Project Name: Sheridan Street Apartments

Address: 152-156 SHERIDAN ST

Project Description: New construction of three level, multi-unit residential complex consisting of 5 units with attached garage.

AUTOTURN MOVEMENT
AASHTO 2011-P (LARGE CAR)
STALL NO. 1

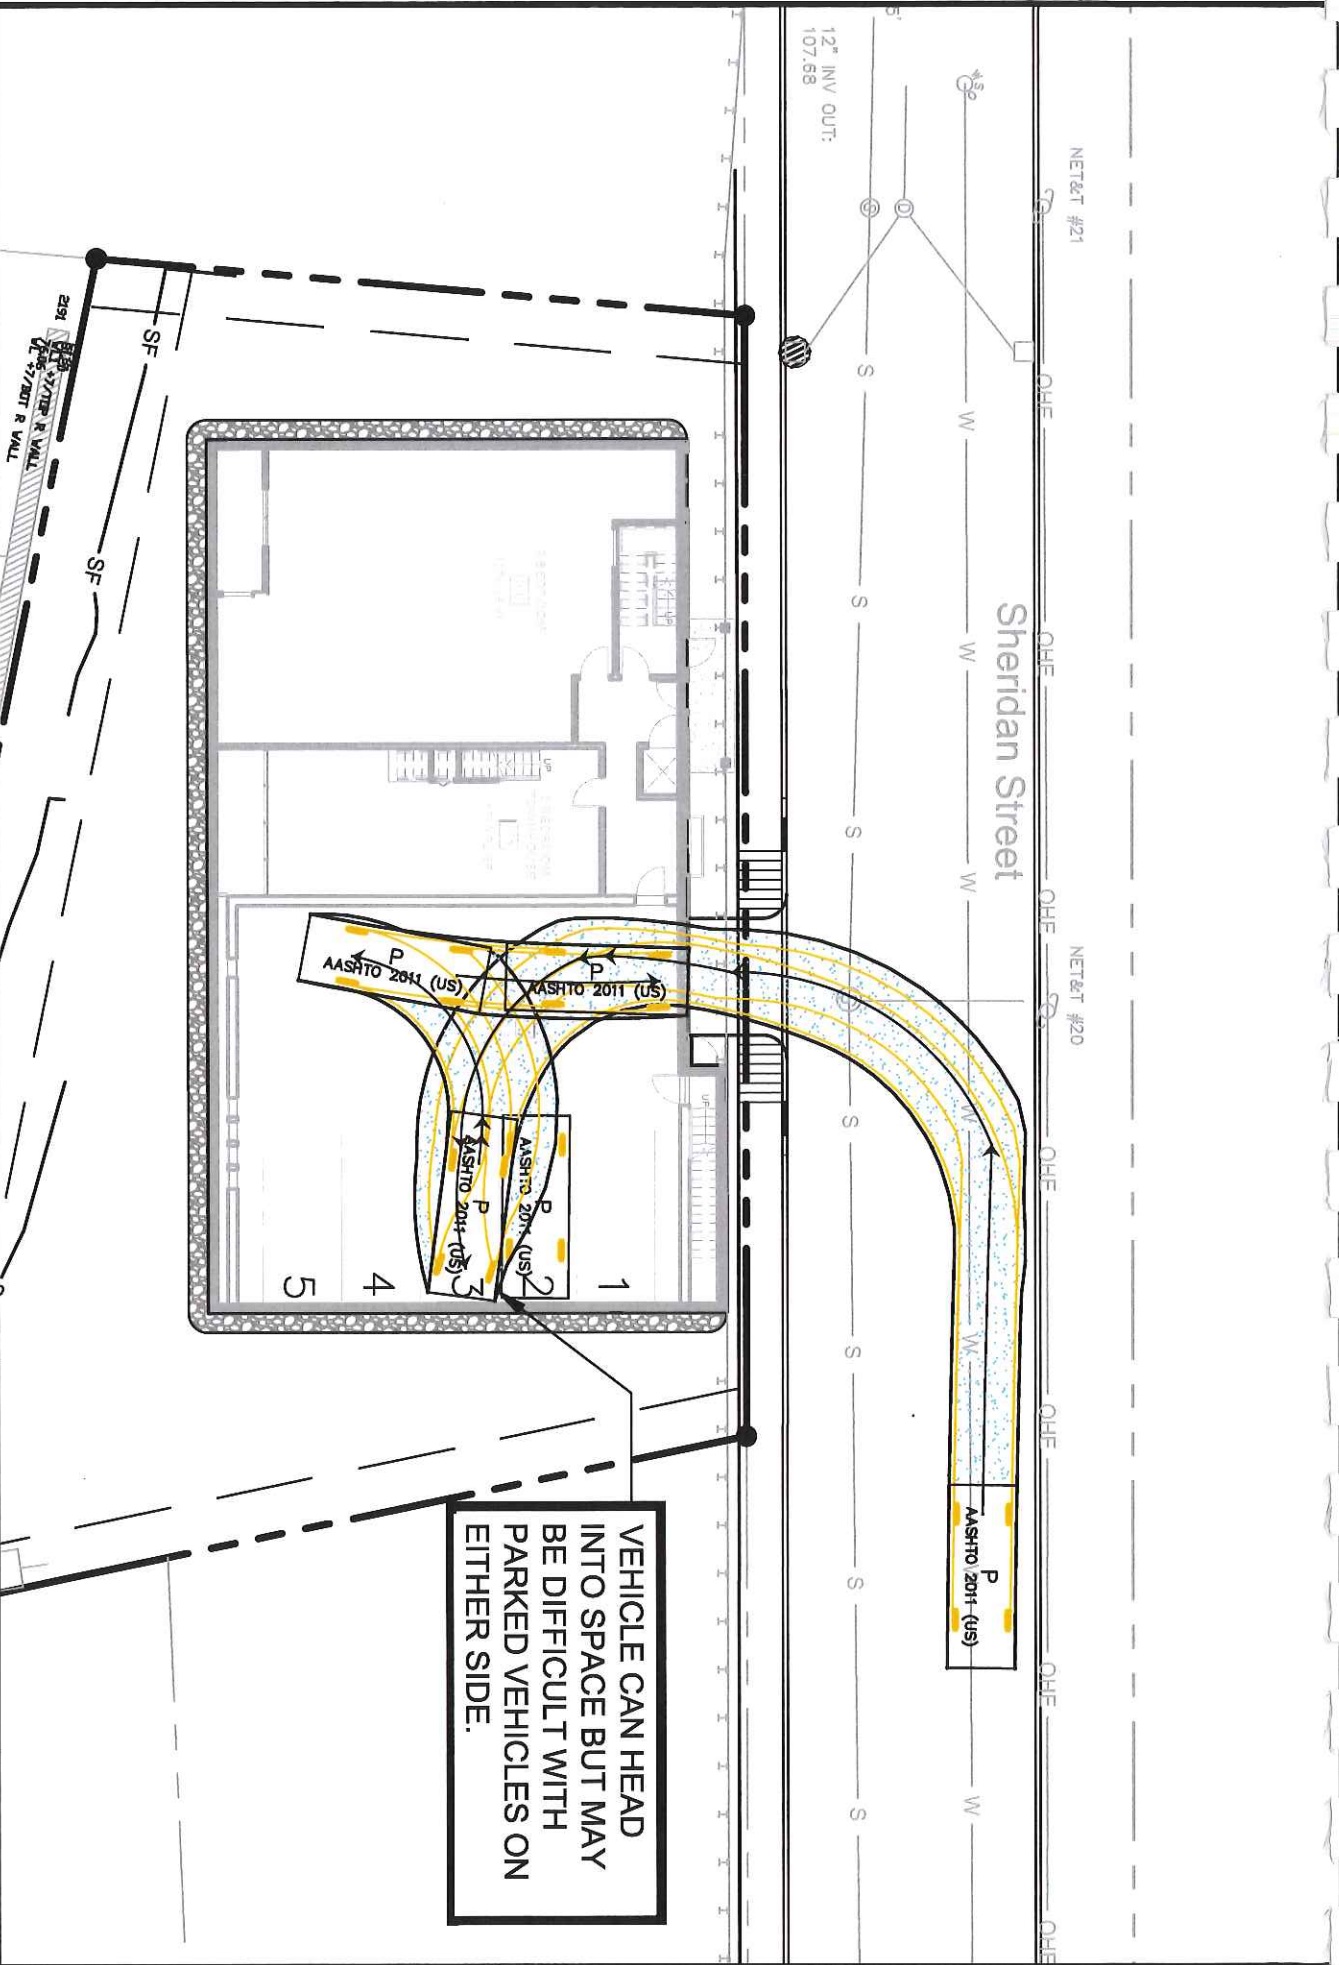
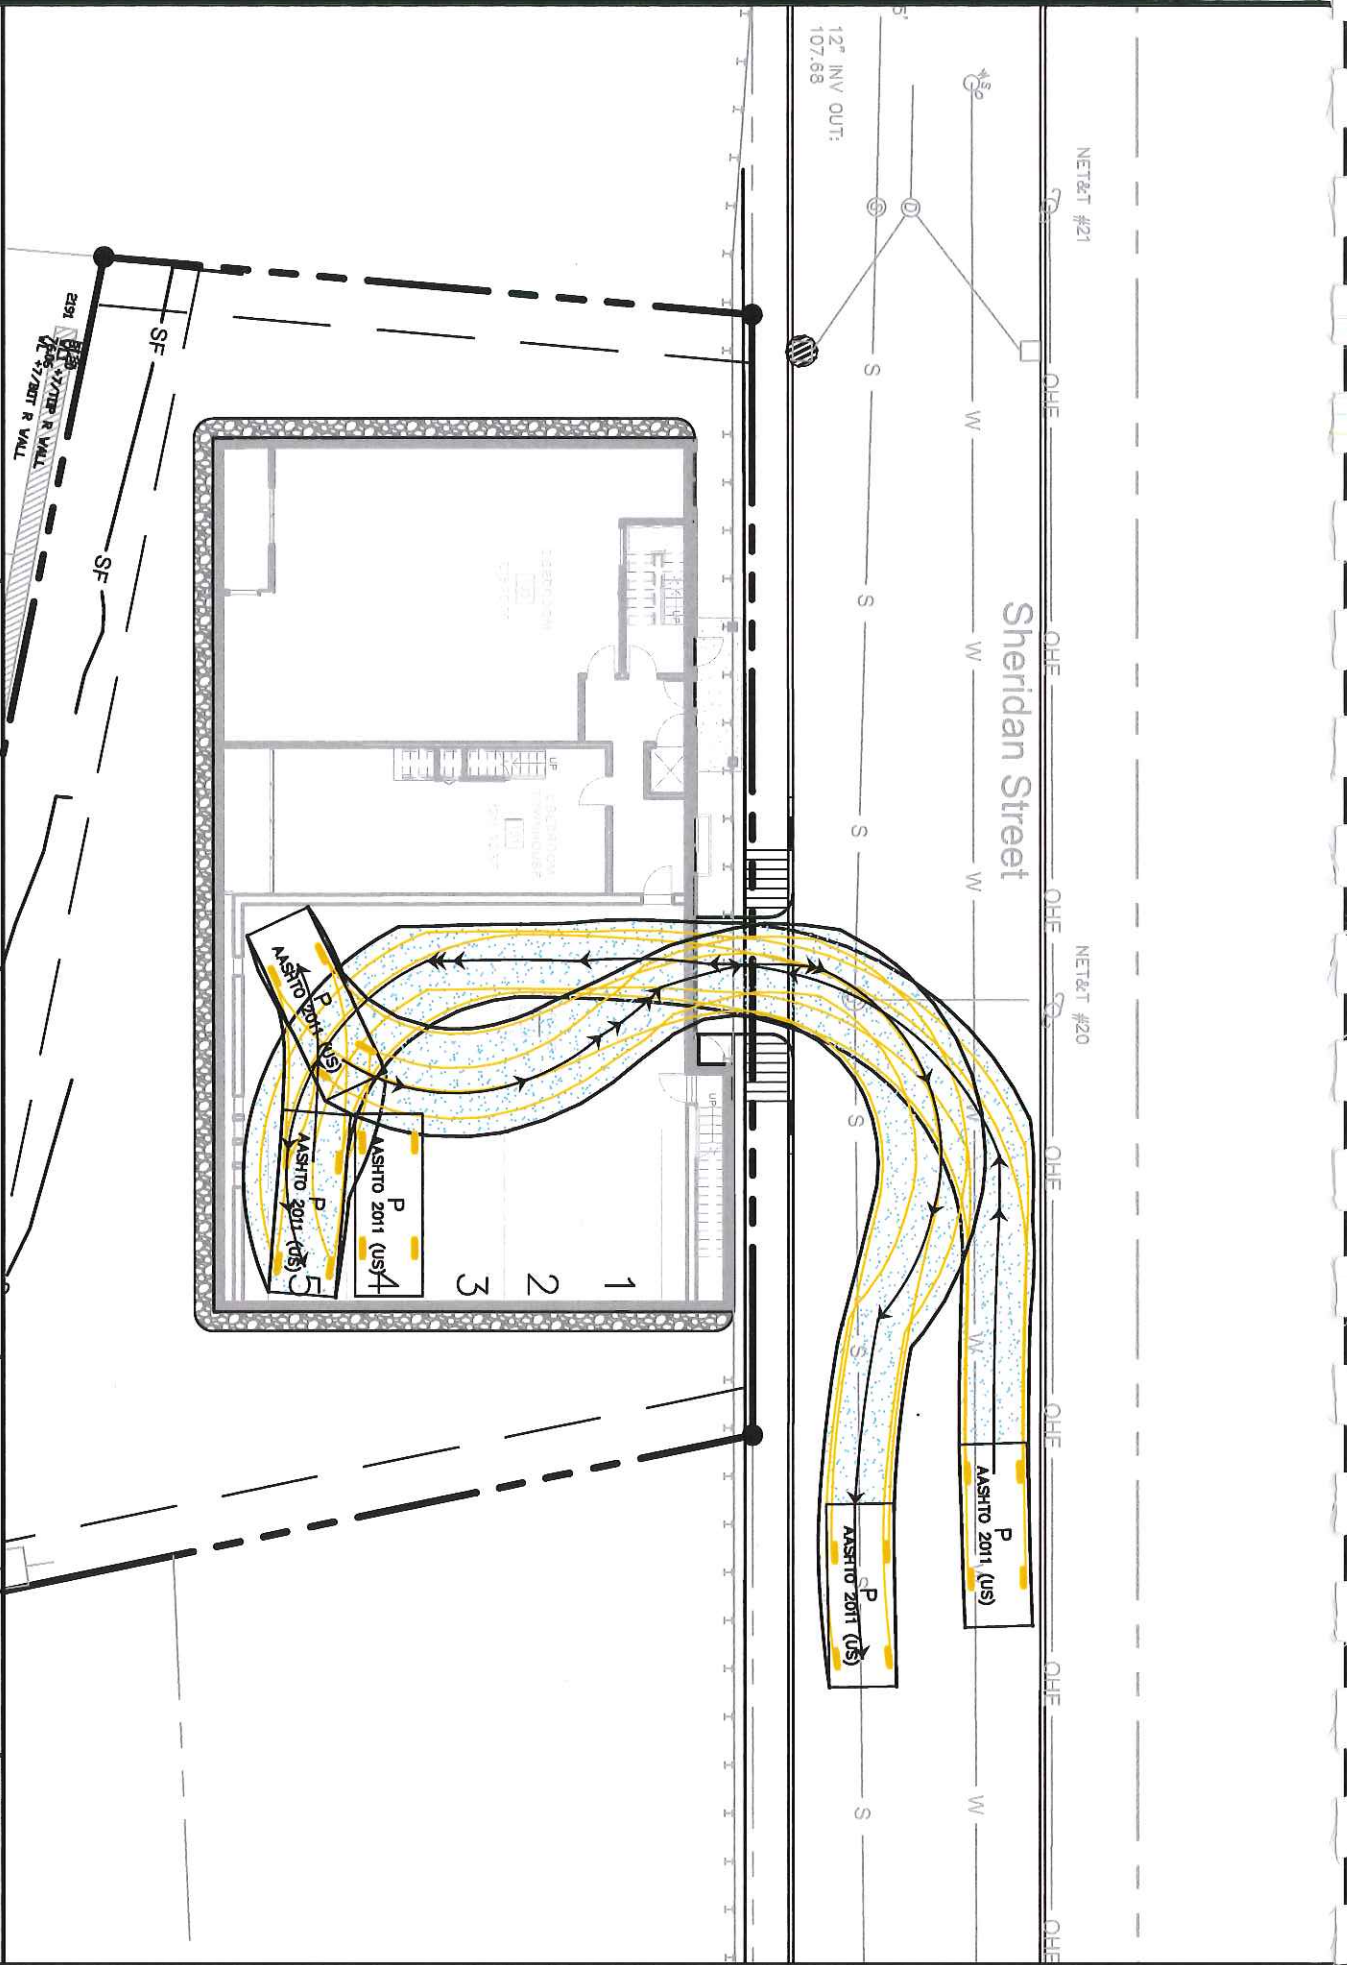
drawn, these spaces are smaller than the city’s standard. Turning templates for the interior parking area have been provided. Of the proposed parking plan, Mr. Errico writes,

The interior garage parking aisle is approximately 23 feet wide and is slightly less than City dimensional standards. I support a waiver for the proposed condition. In my professional opinion site vehicles will be able to maneuver on site without backing into Sheridan Street.

Parking space width dimensions are slightly narrower than City standards (8.5 feet vs. 9.0 feet). I support a waiver for the proposed condition.

Formal waiver requests should be included in the revised submittal.

FIRST FLOOR PLAN

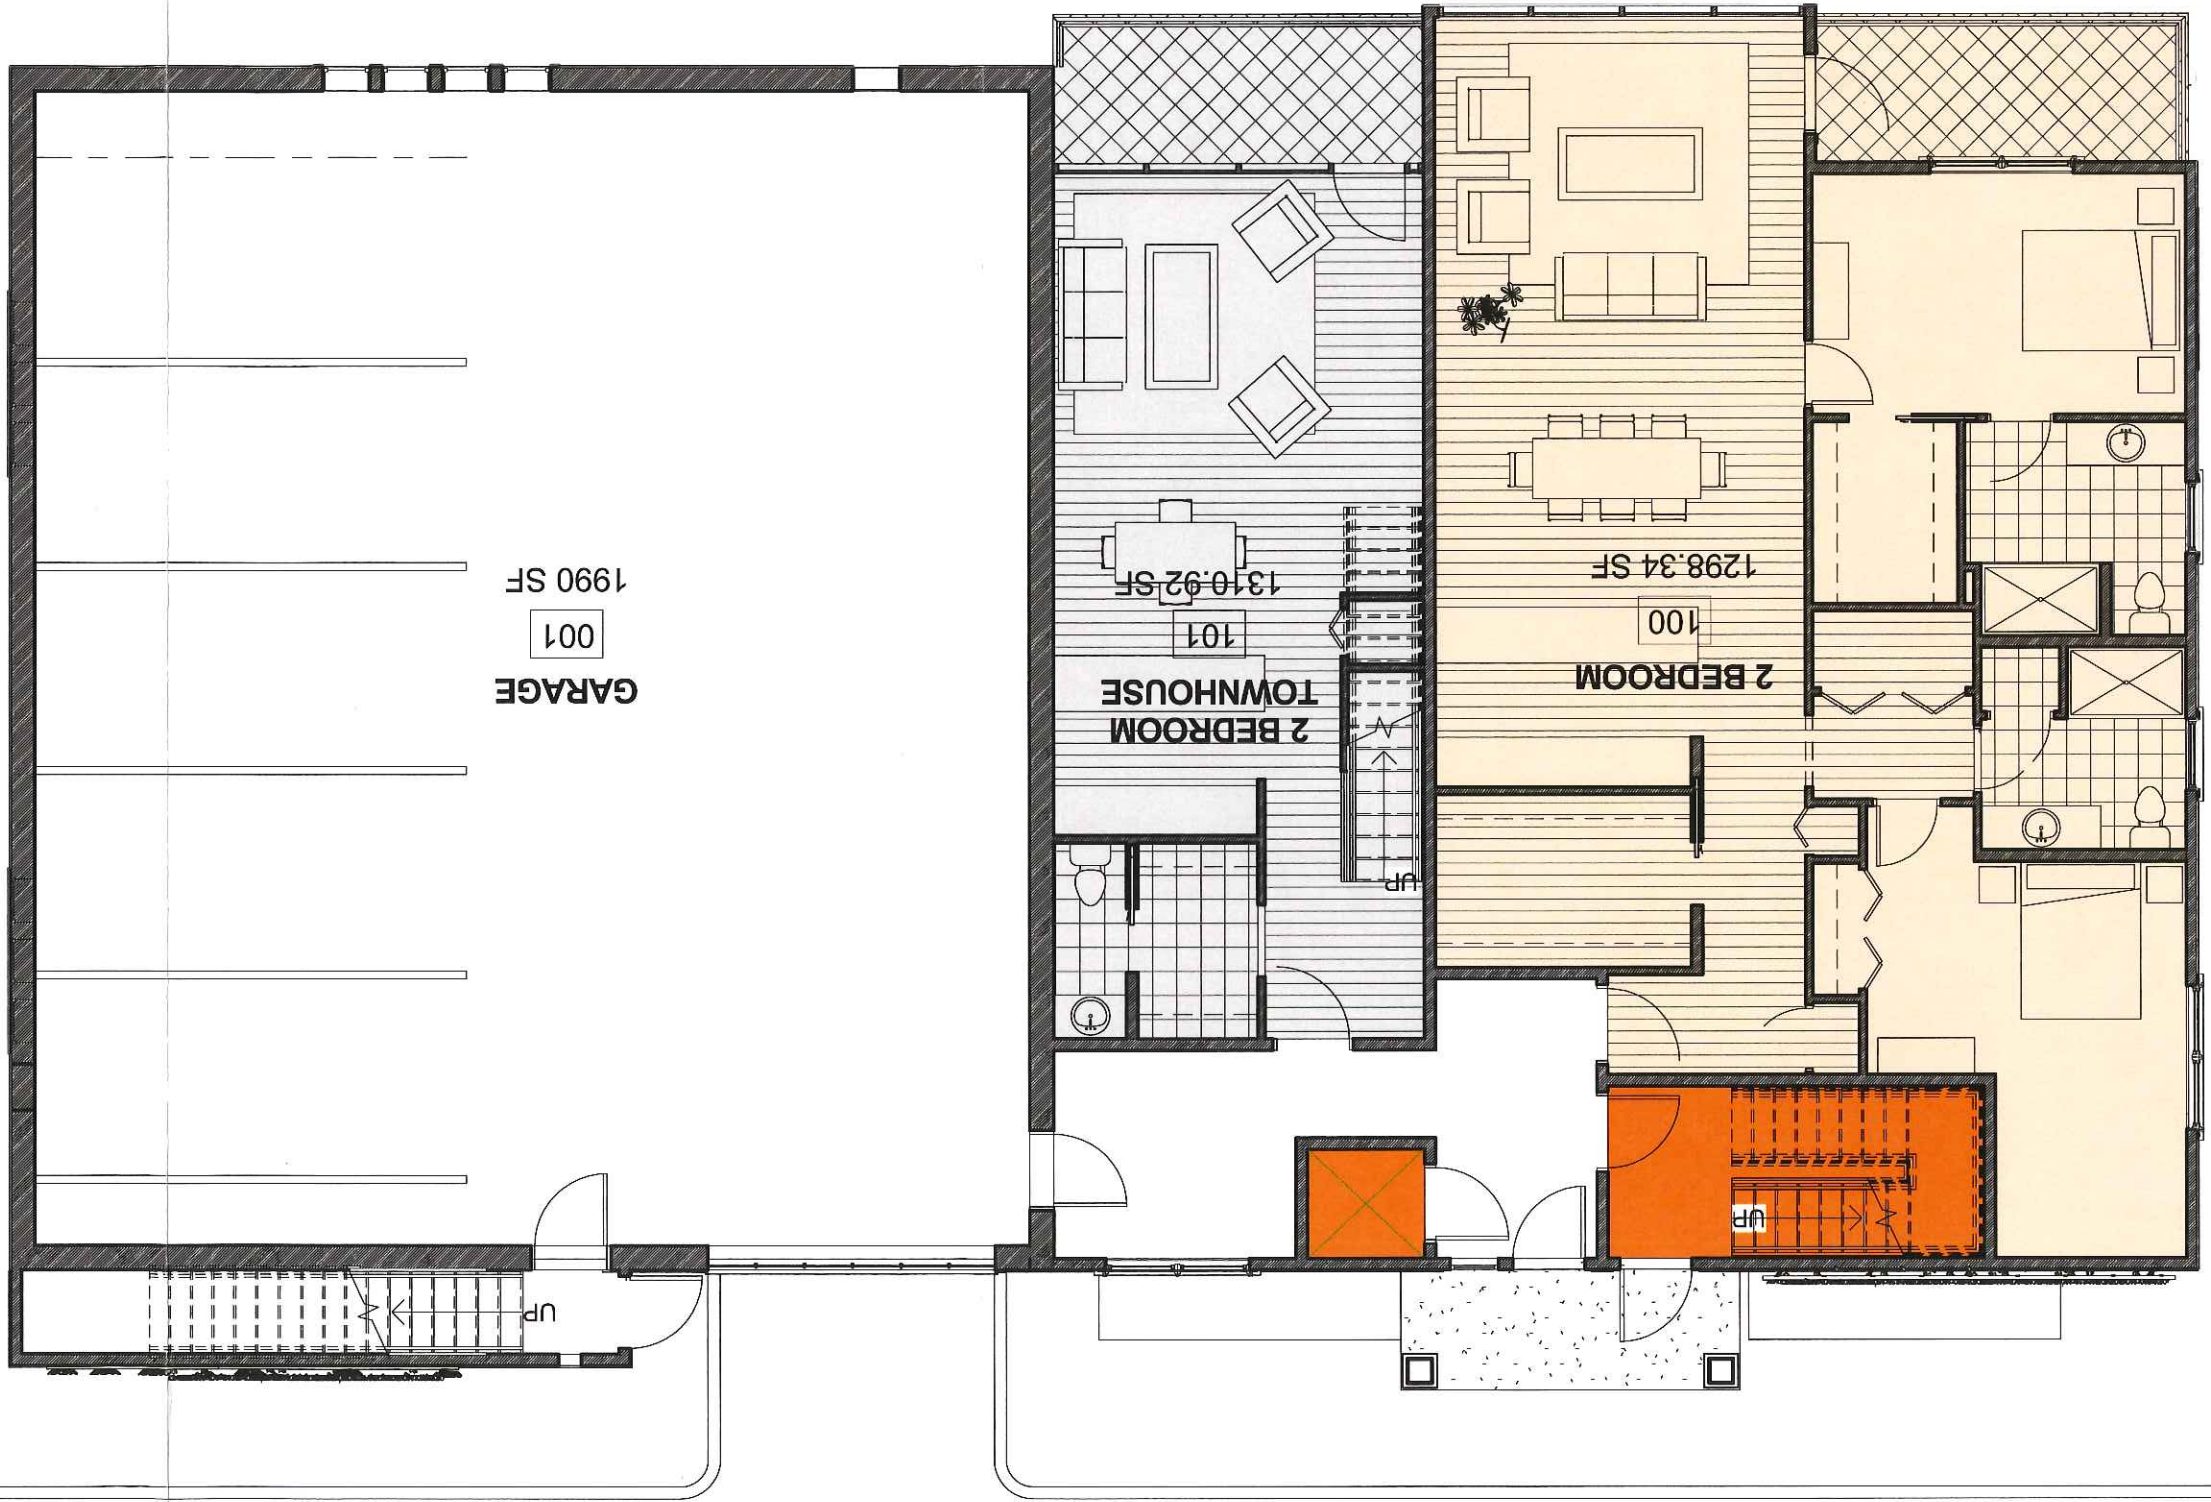
The applicant states that a private contractor would be used for waste management purposes. Temporary storage of trash and recyclables in an interior trash room is proposed. The location of this facility should be depicted on the final floor and site plans.
